**CITY OF ALBUQUERQUE
PLANNING DEPARTMENT
August 6, 2014
DRB Comments**

PROJECT # 1010010

RE: Lots 19-20, Block 4, Tr. 3 Unit 3 North Albuquerque Acres

**Signal Pointe
Subdivision**
BEING AND COMPRISING
LOT 19 and 20, BLOCK 4
TRACT 3, UNIT 3
NORTH ALBUQUERQUE ACRES
ALBUQUERQUE, BERNALILLO COUNTY,
NEW MEXICO

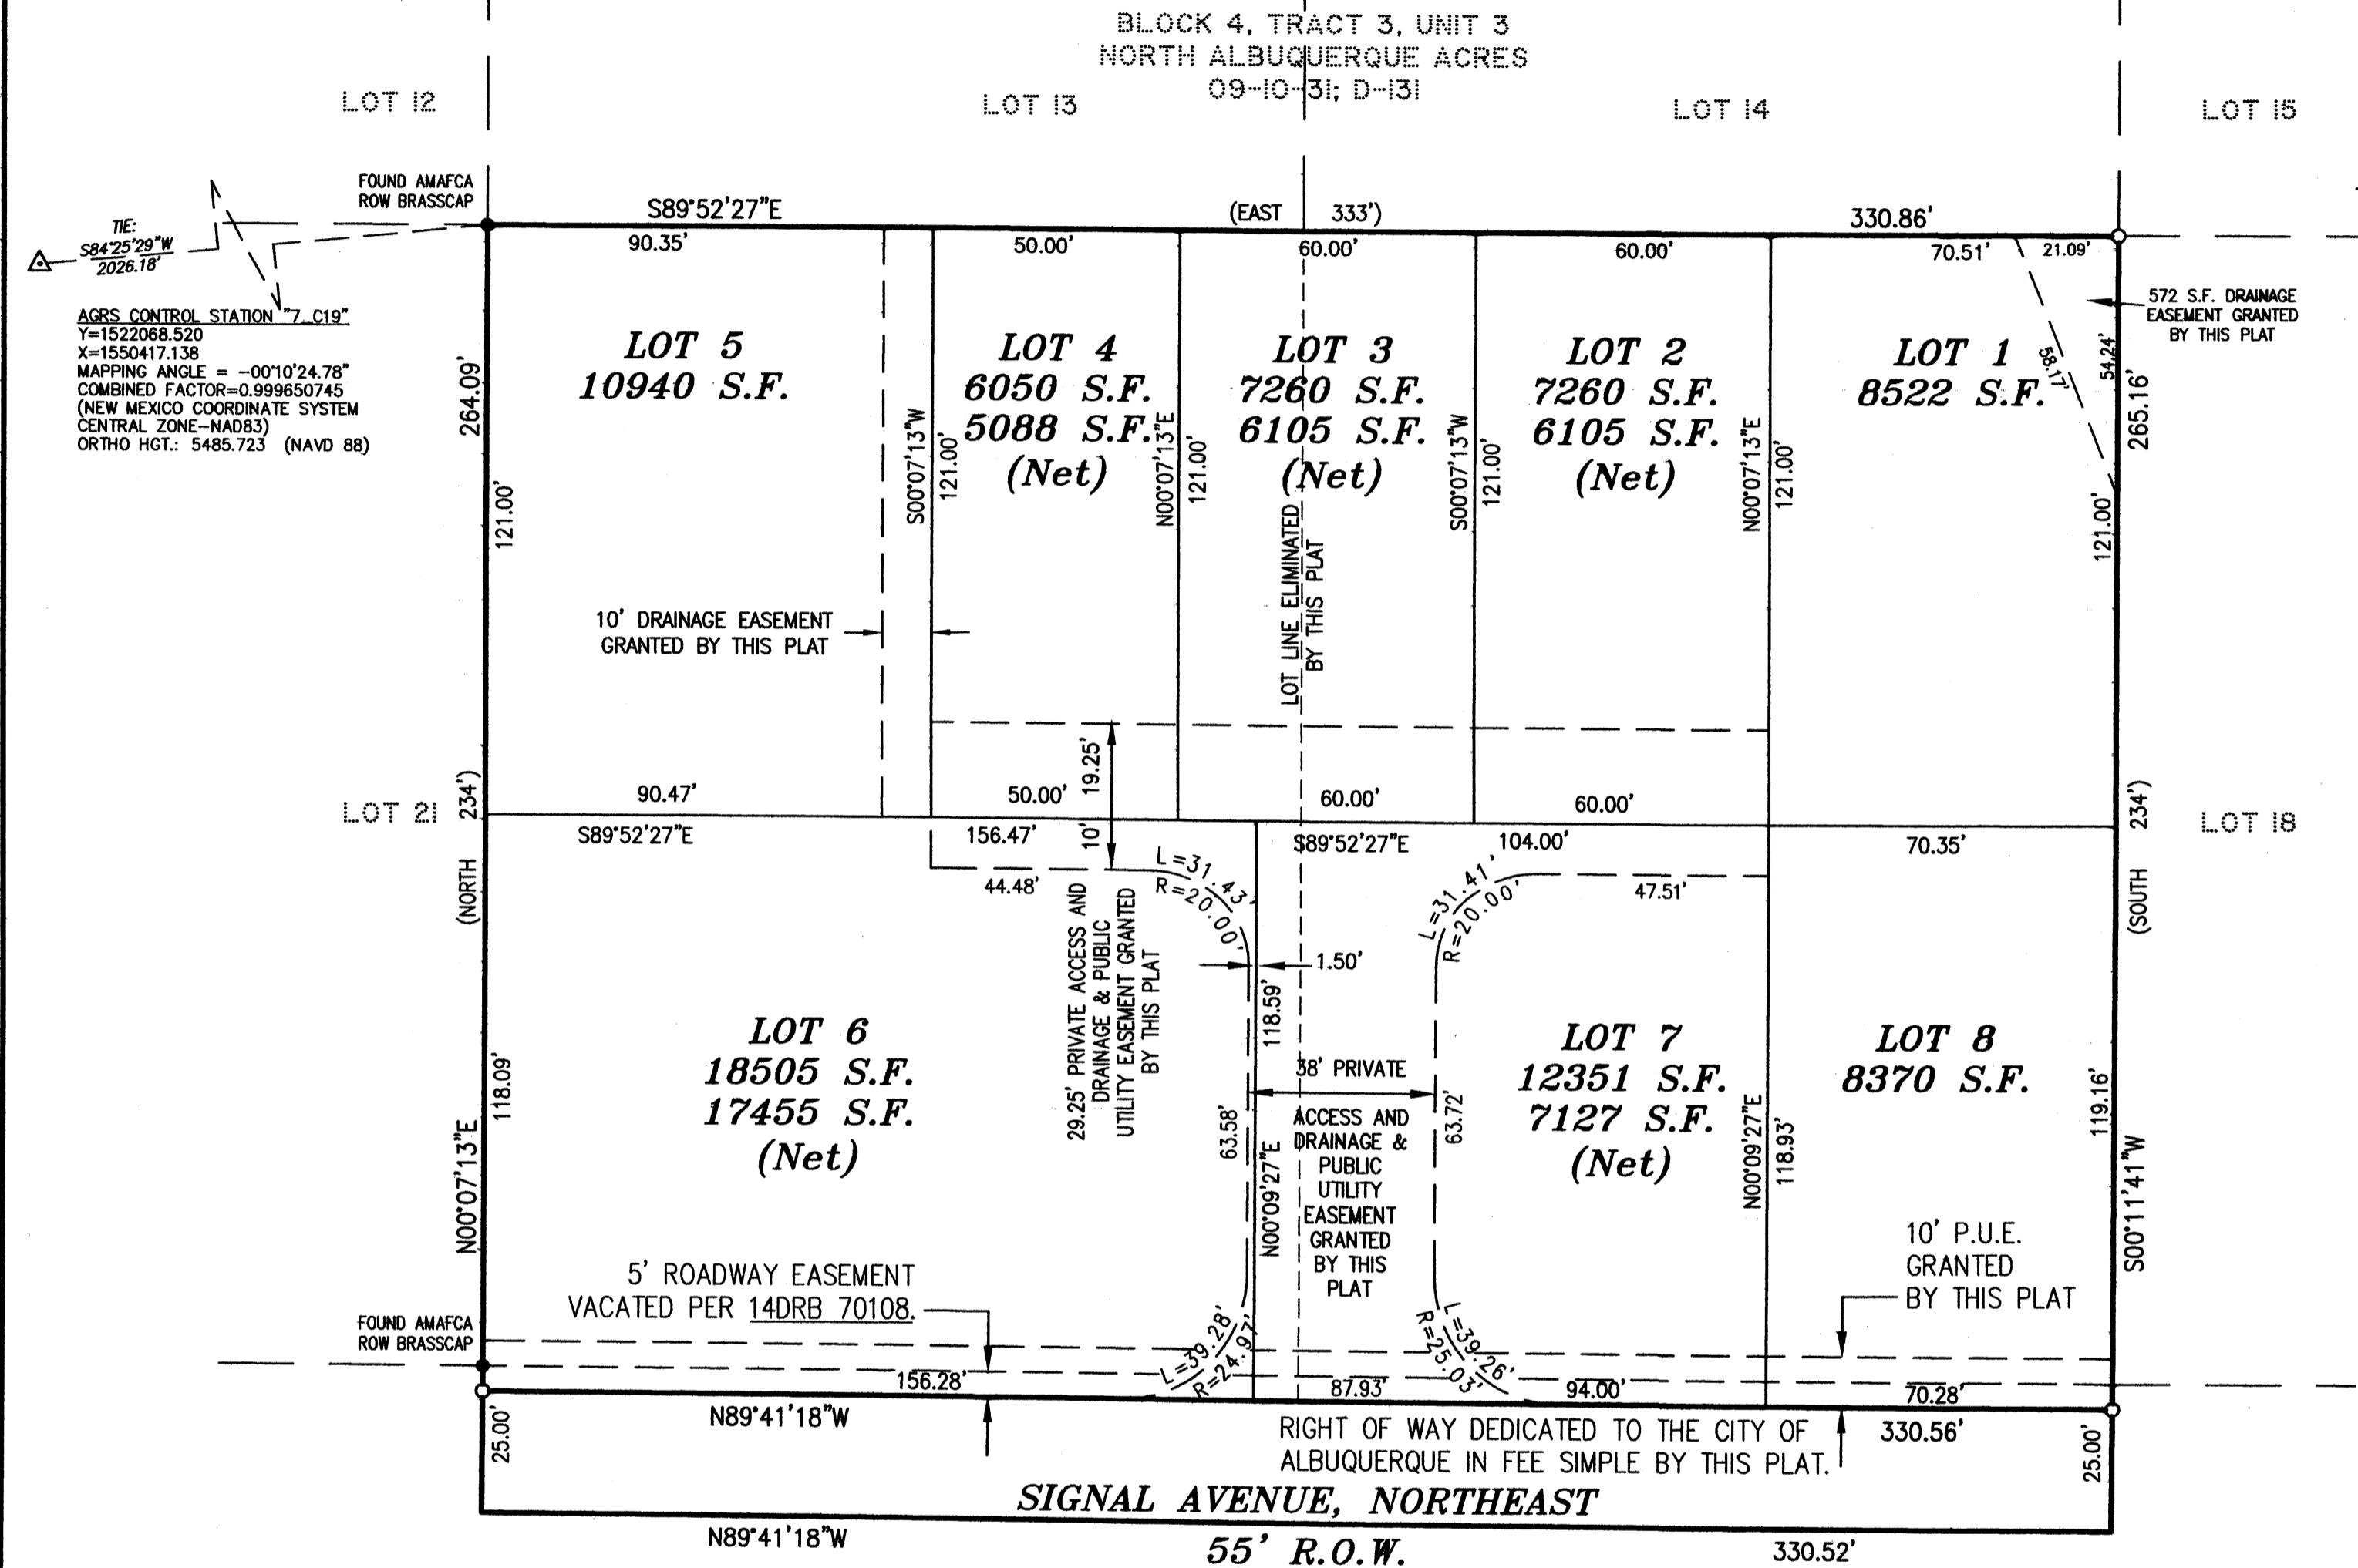
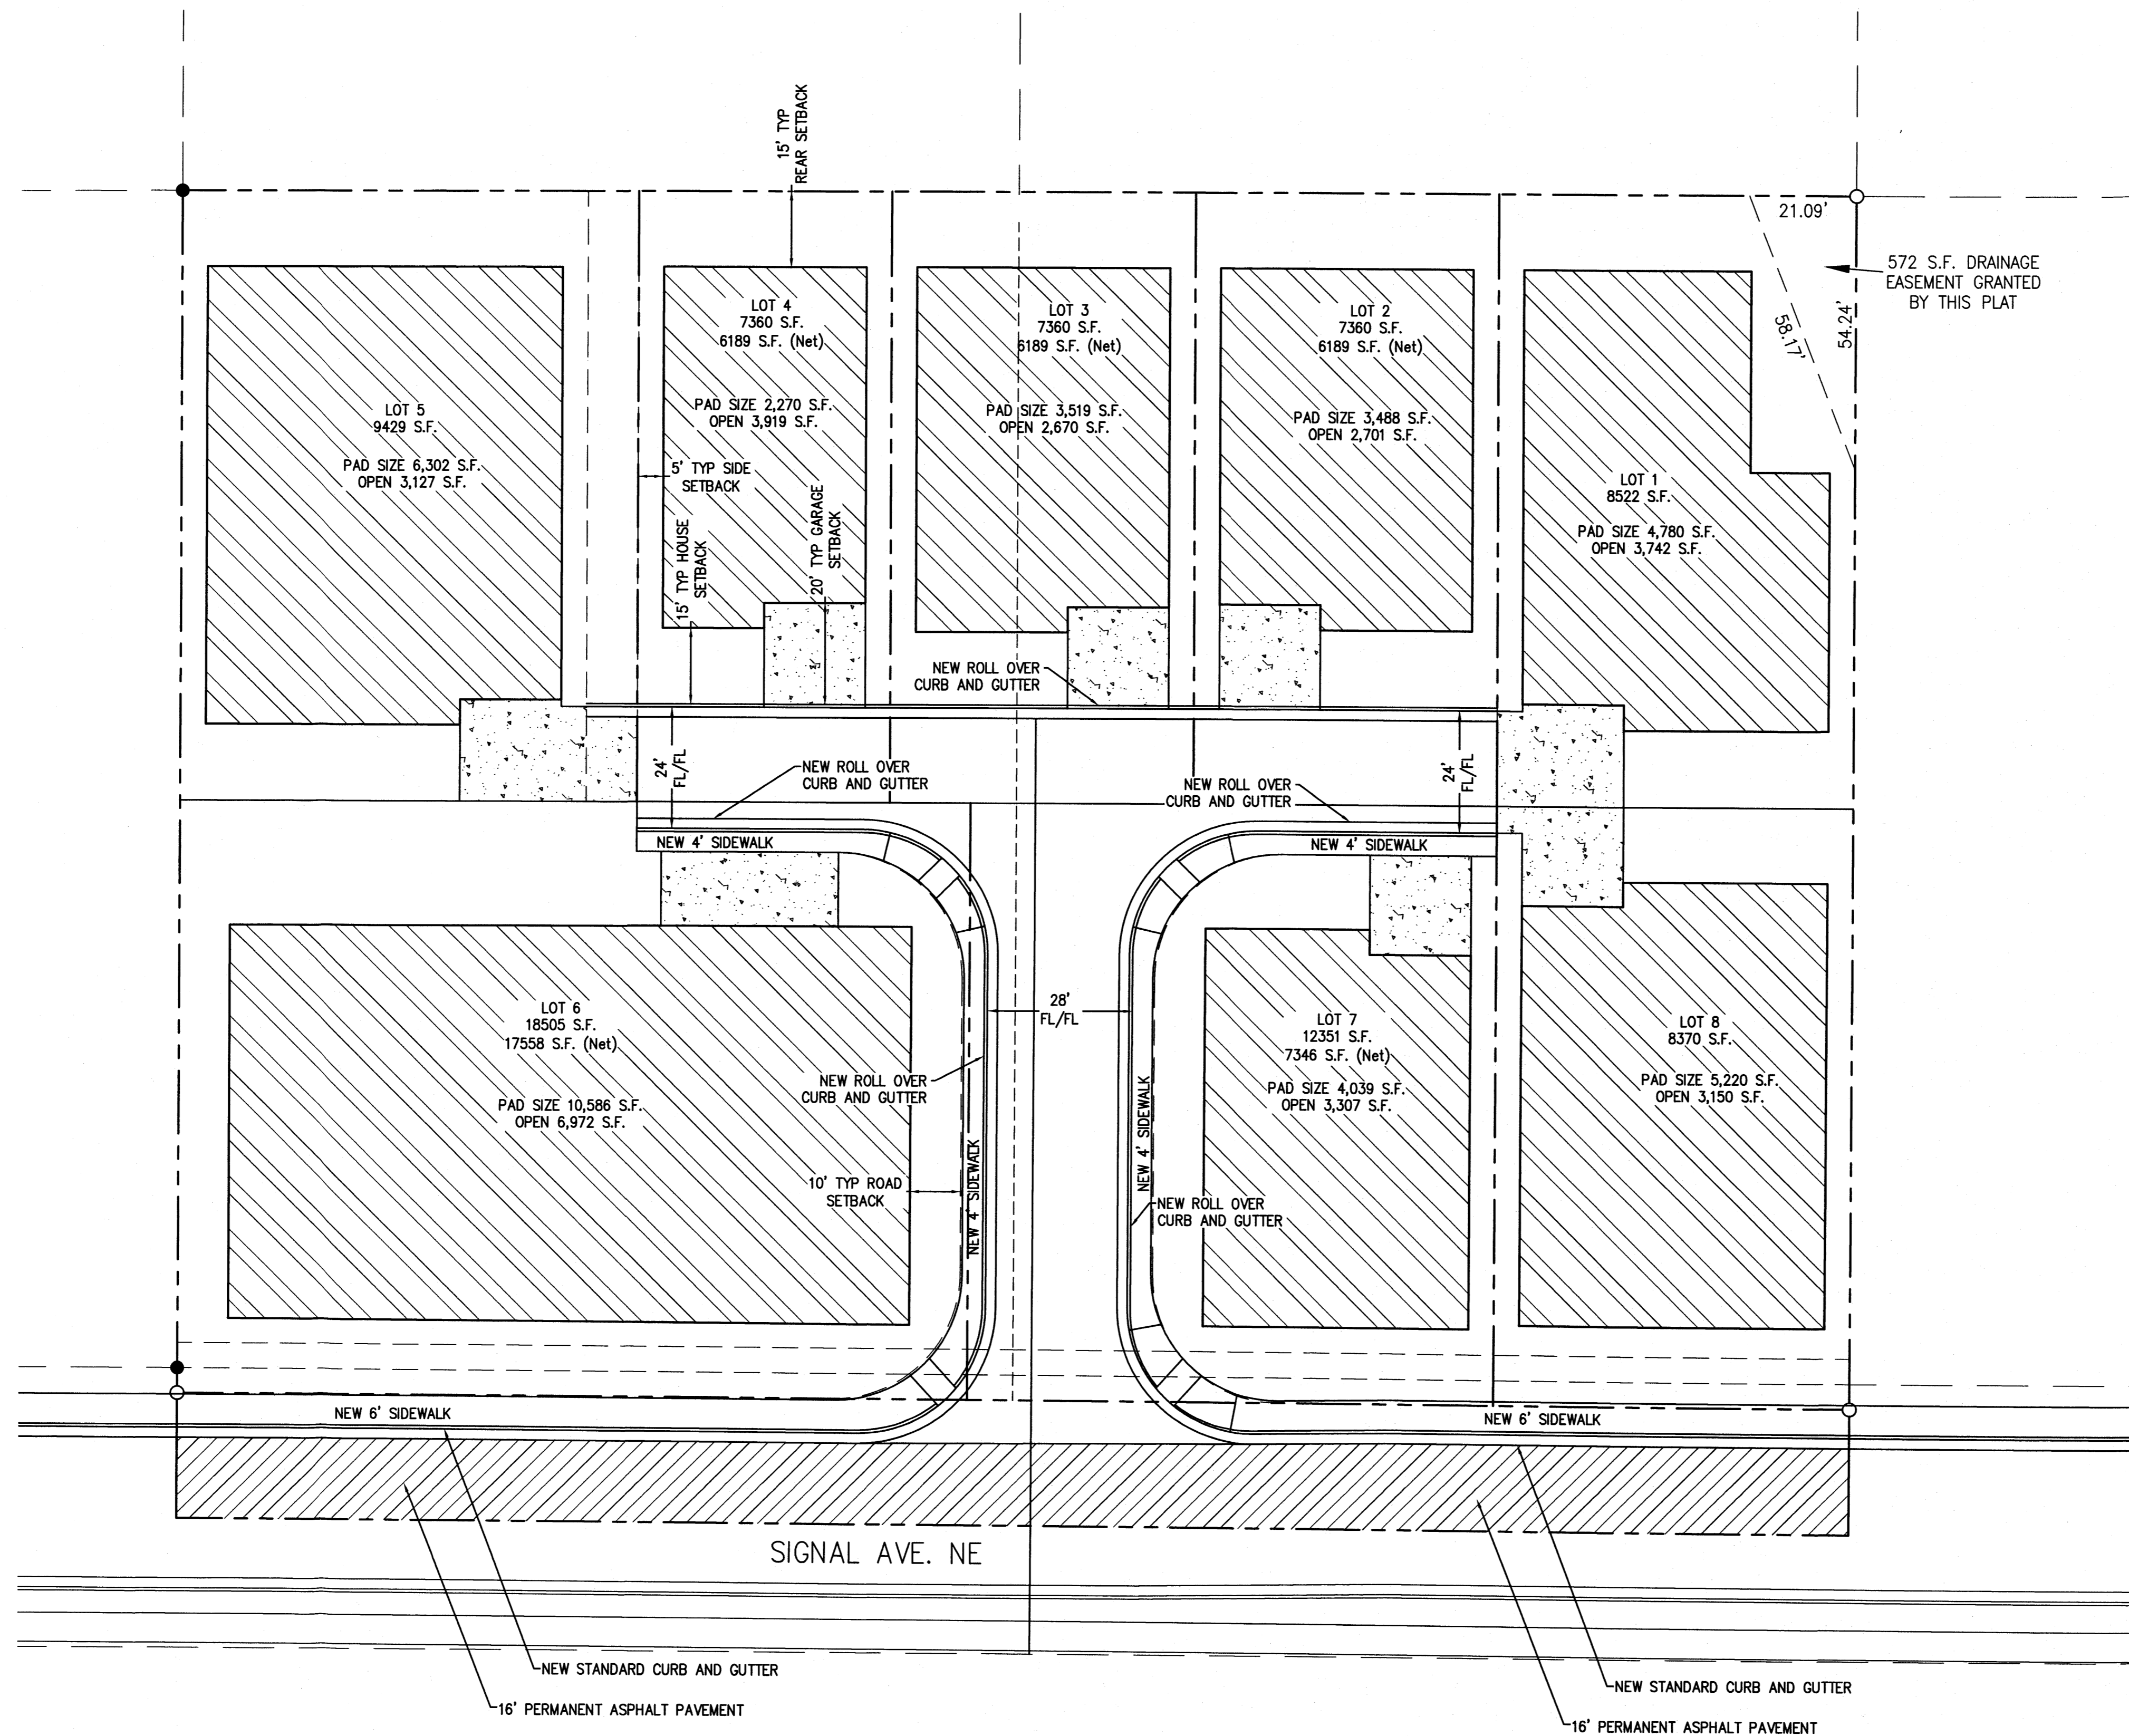
The cross section for the north/south section of Signal Pointe needs to show the sidewalks at the edge of the easement with landscape on the streetside, not on the outside as shown.

A Sidewalk Variance requires a separate, specific application on Form V; Planning would have no objection to a single sidewalk on the south side of the east-west section of Signal Pointe.

The Private Easement needs to call out beneficiaries, and needs to allow specifically for Public Water and Public Sewer. The east end of Signal Pointe Access Easement does not adequately serve Lot 8; additional easement is needed to allow both lots at the end to have ingress and egress.

LOT 19 and 20, BLOCK 4
TRACT 3, UNIT 3
NORTH ALBUQUERQUE ACRES
ALBUQUERQUE, BERNALILLO COUNTY,
NEW MEXICO

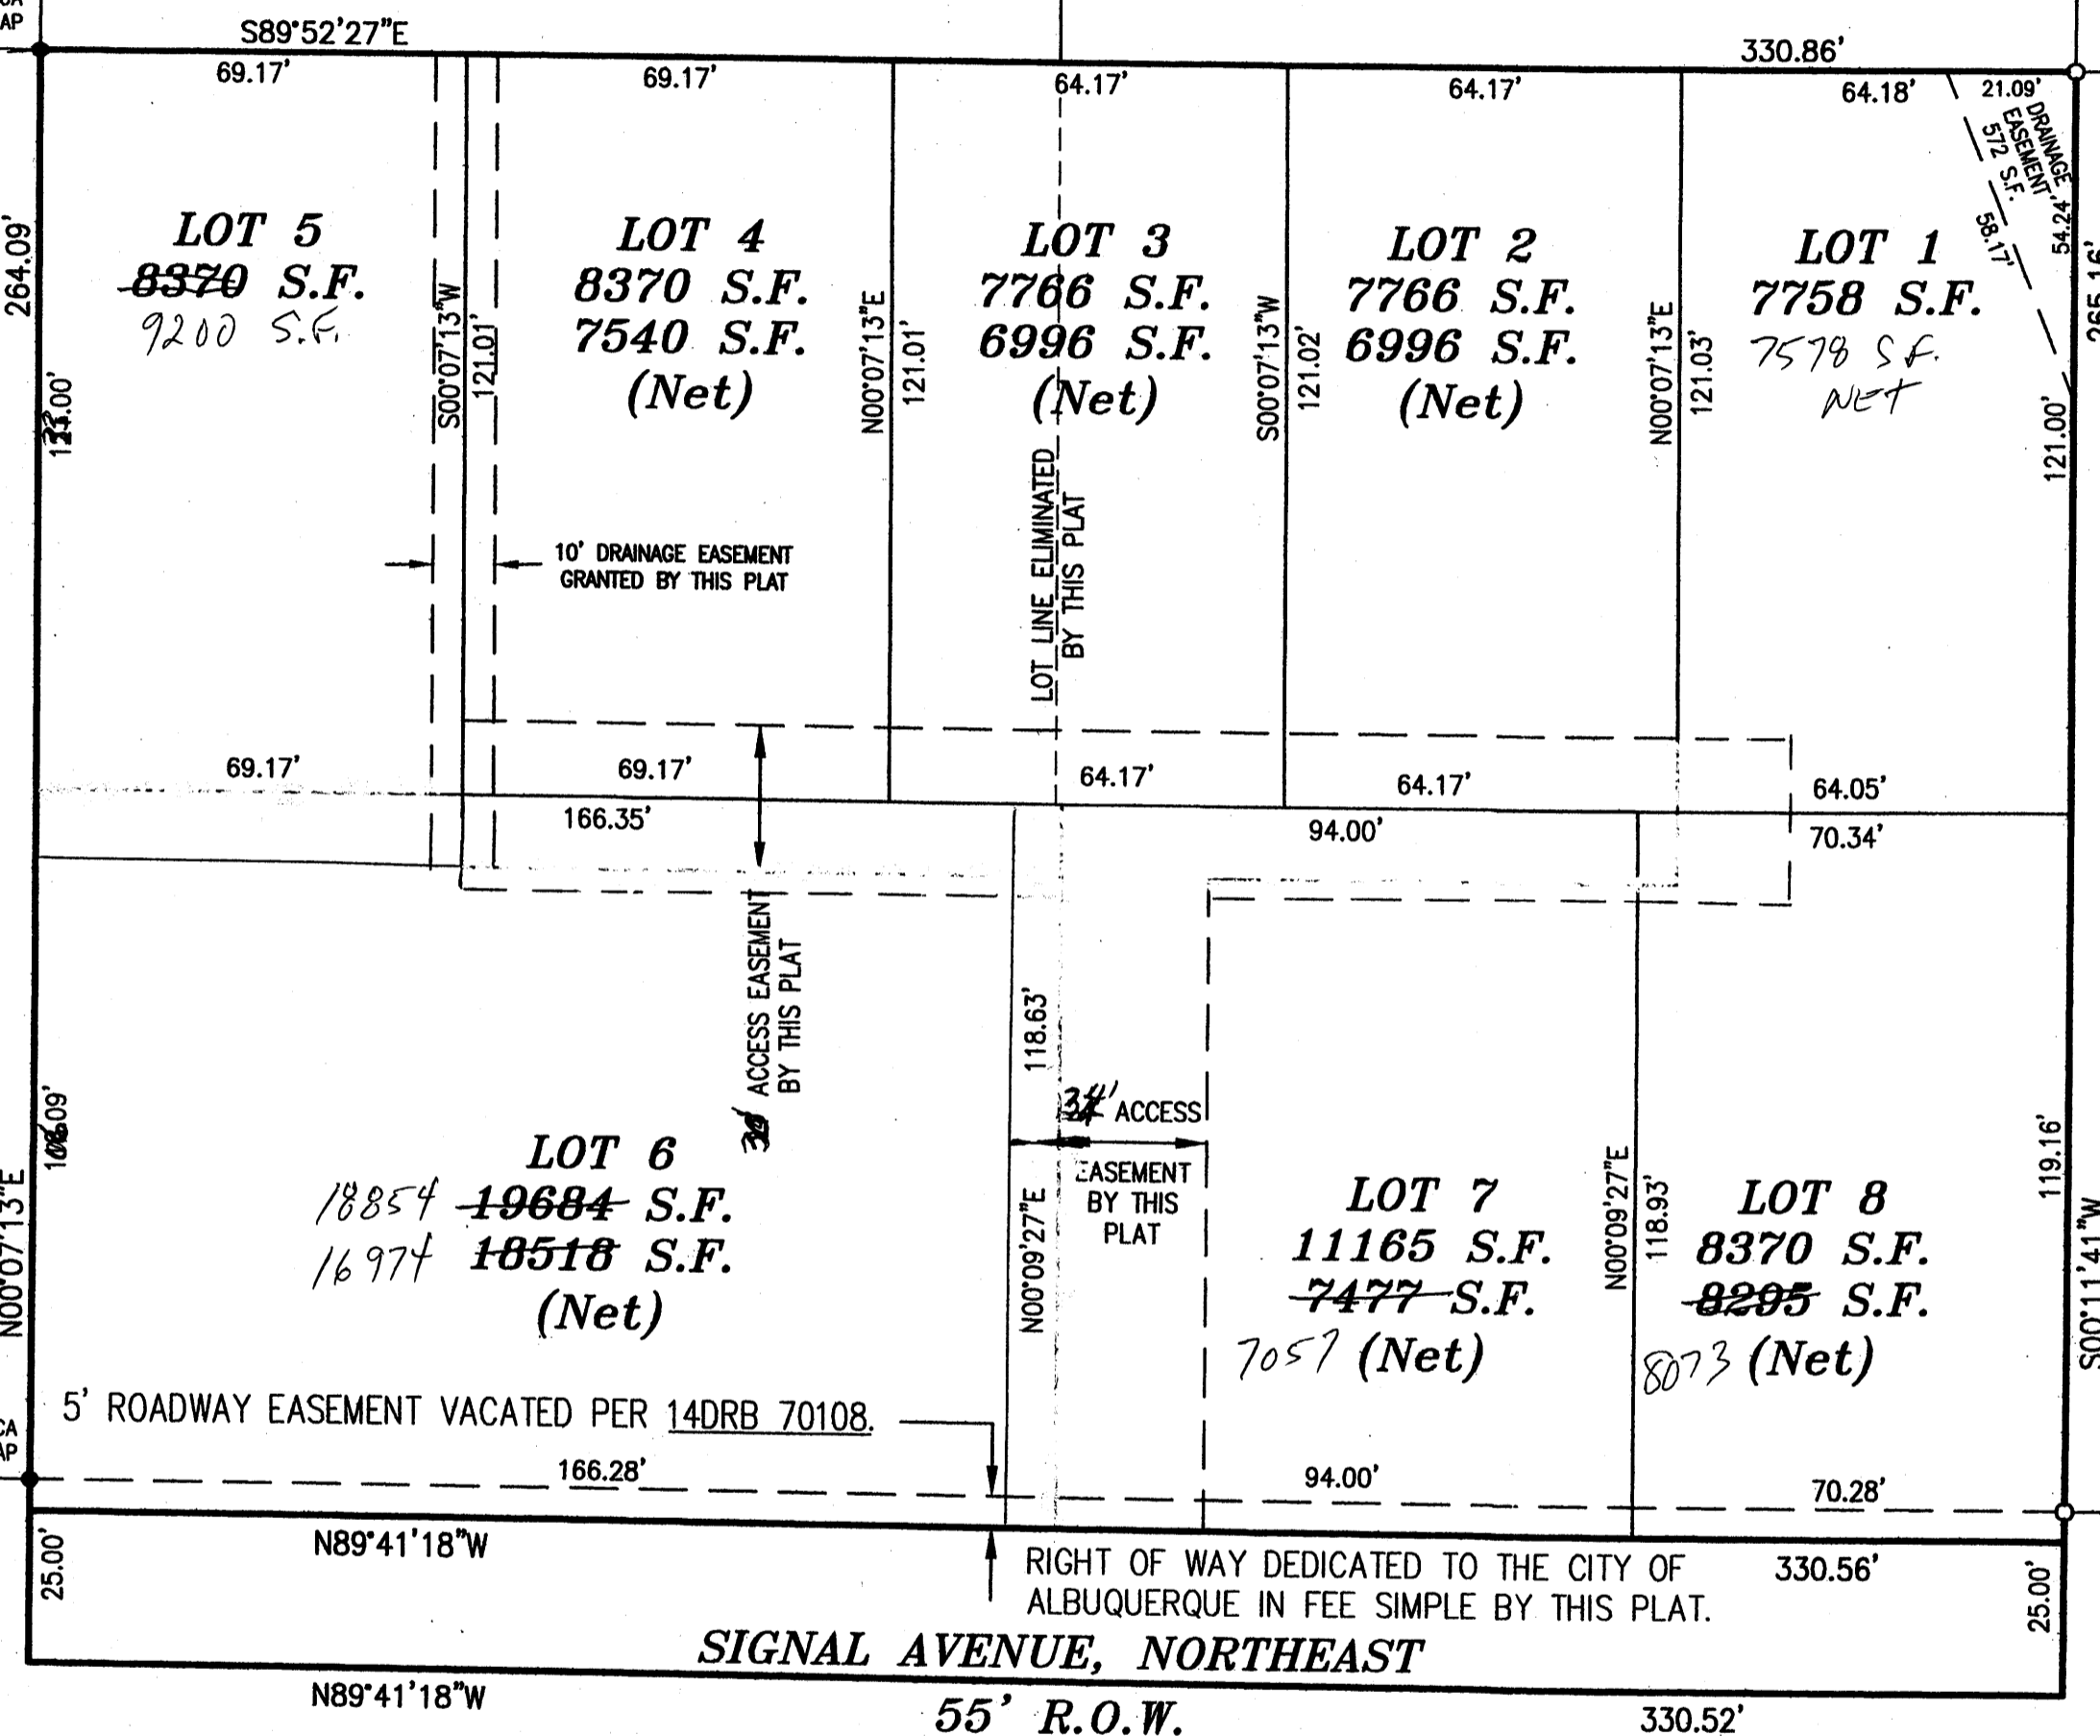
Please clarify the intent/ authority of the "Solid Waste Approval" note.

Planning would have no objection to a Sidewalk Variance for a single sidewalk on the south side of the east-west access, however a reduction in easement width and sidewalk location are not appropriate for pedestrian safety and to discourage parking on sidewalks, especially with the use of roll curbs – refer to Table 23.2.2 of the DPM (38' Easement for 2 sidewalks, 32' Easement for 1 sidewalk).
